Our Ref: LU/99/11/

Change of use from (A1) kiosk to (A3) cafe to include replacing timber boarded front elevation with glazing & fit security shutters to door & window openings. Re-site fryer flue & fix flag & install 2 no. toilets & storage unit at rear
West Beach Cafe Rope Walk Littlehampton

I regret that I am unable to accept your documents as a formal application until the following matters have been resolved :-

PLAN OF PROPOSED W.C.'s AND STORAGE UNIT LOCATED AT WEST BEACH CAFE, LITTLEHAMPTON. BN17 5DE.

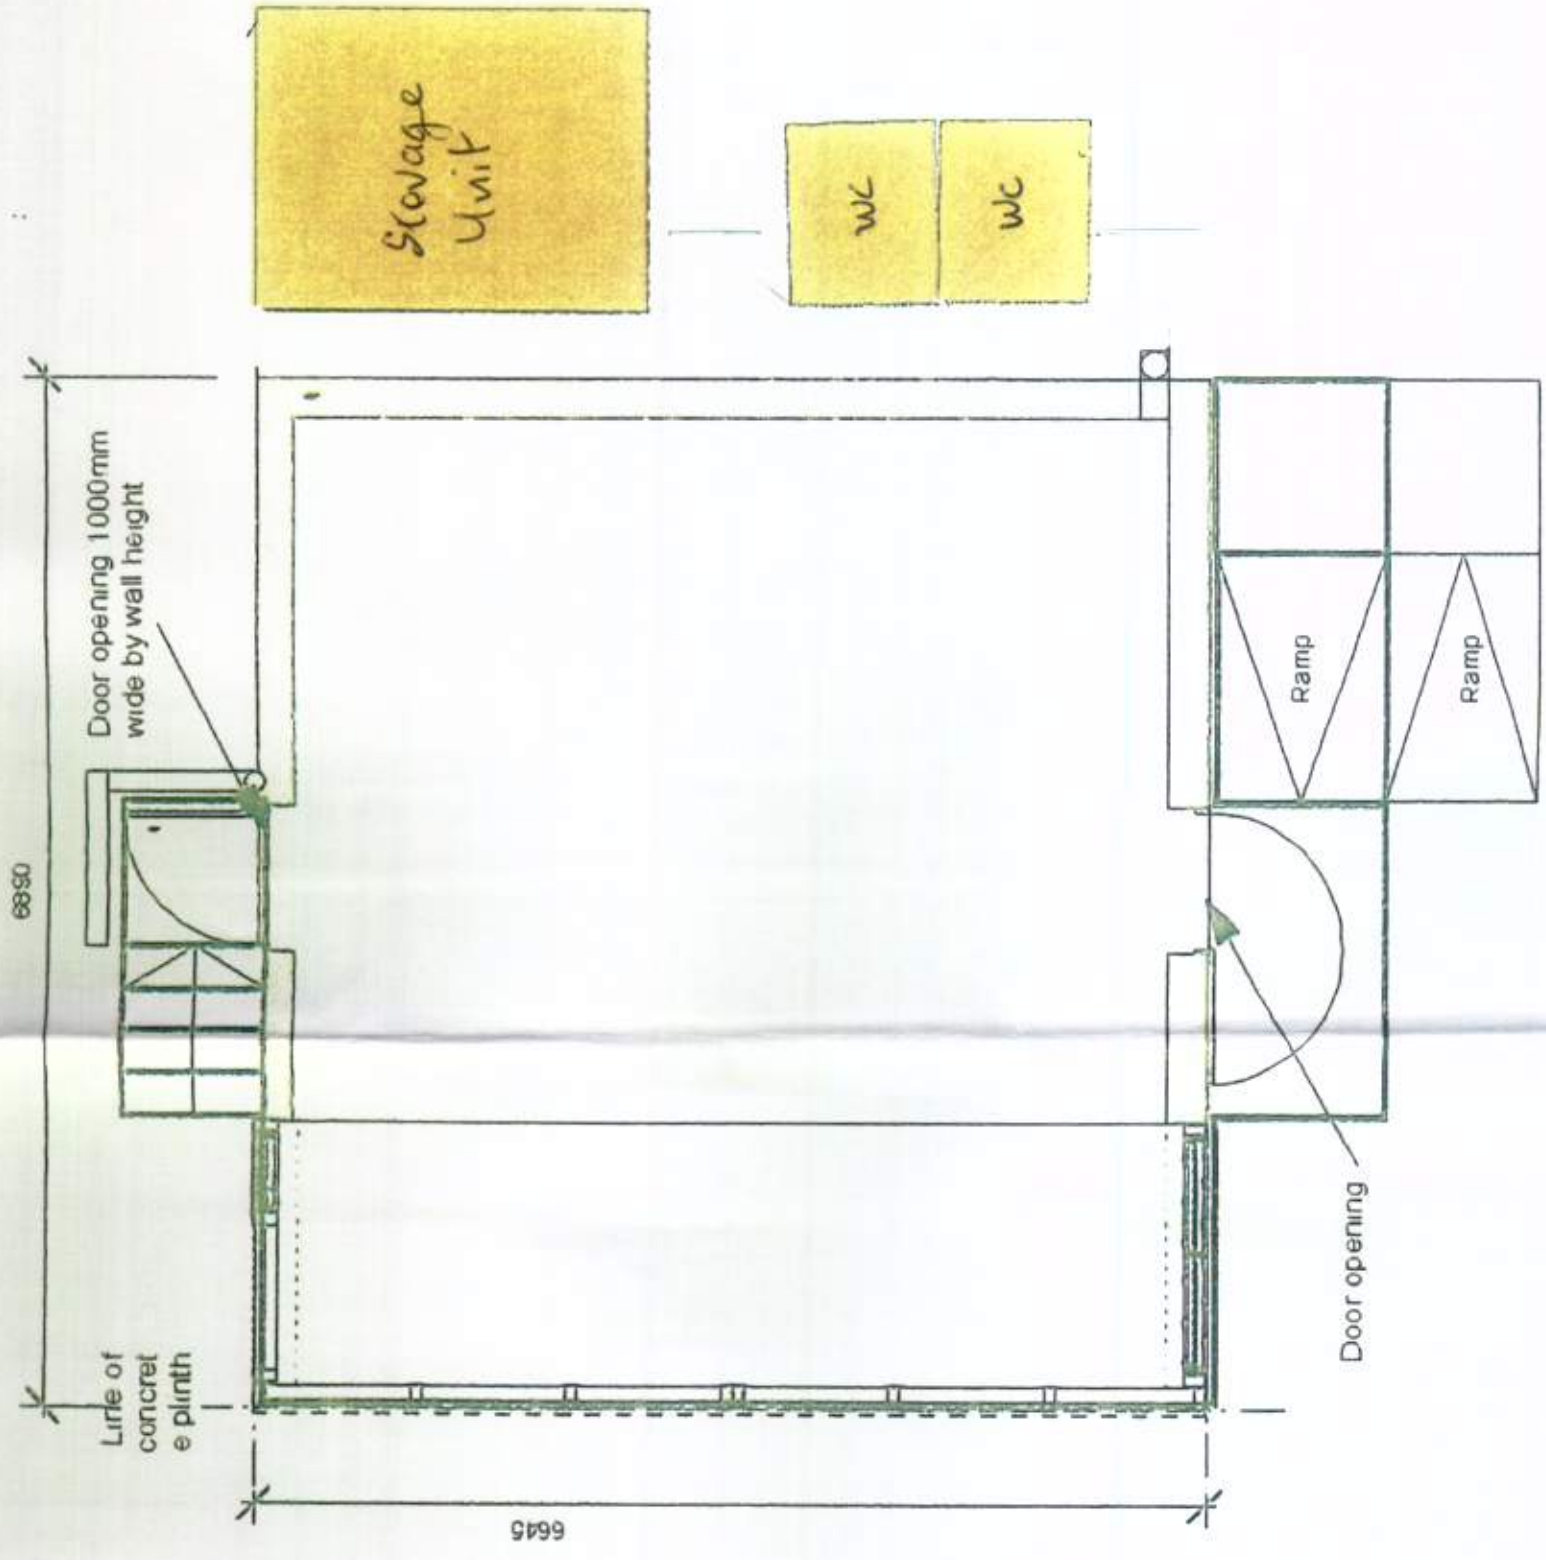
Please provide 1 electronic or 3 paper copies of existing and proposed floor plans at a scale of 1:50 or 1:100 (the plan provided is not to scale) showing all the works proposed, in accordance with the guidance notes available on our website detailed below (click on National List).

PROPOSED FLAG. SCALE 1:50

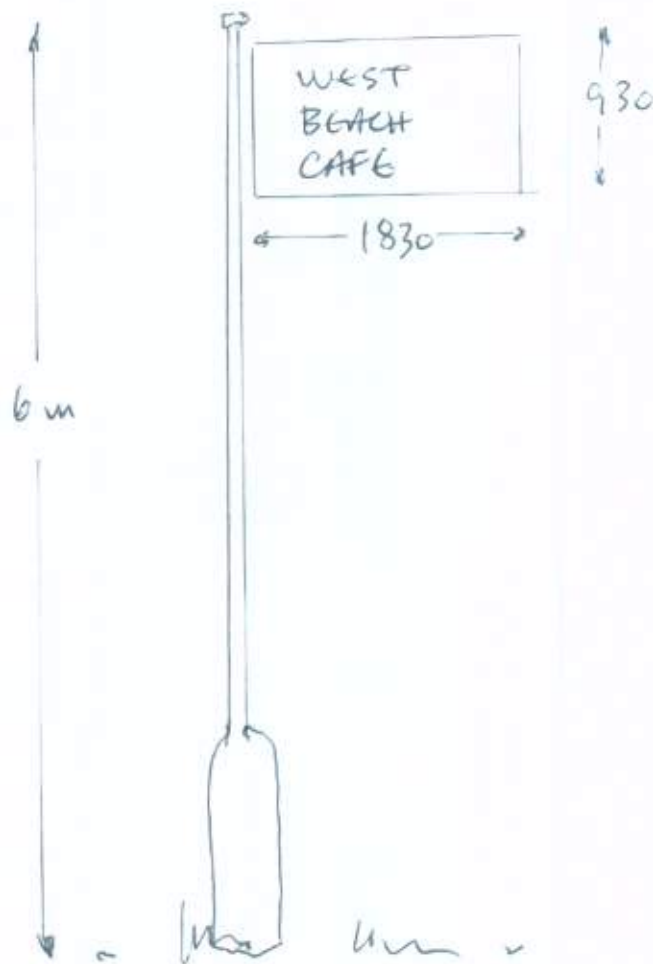
Please provide 1 electronic or 3 paper copies of existing and proposed elevations at a scale of 1:50 or 1:100 (the plans provided are not to scale) showing all the works proposed (to include the proposed flag), in accordance with the guidance notes available on our website detailed below (click on National List).
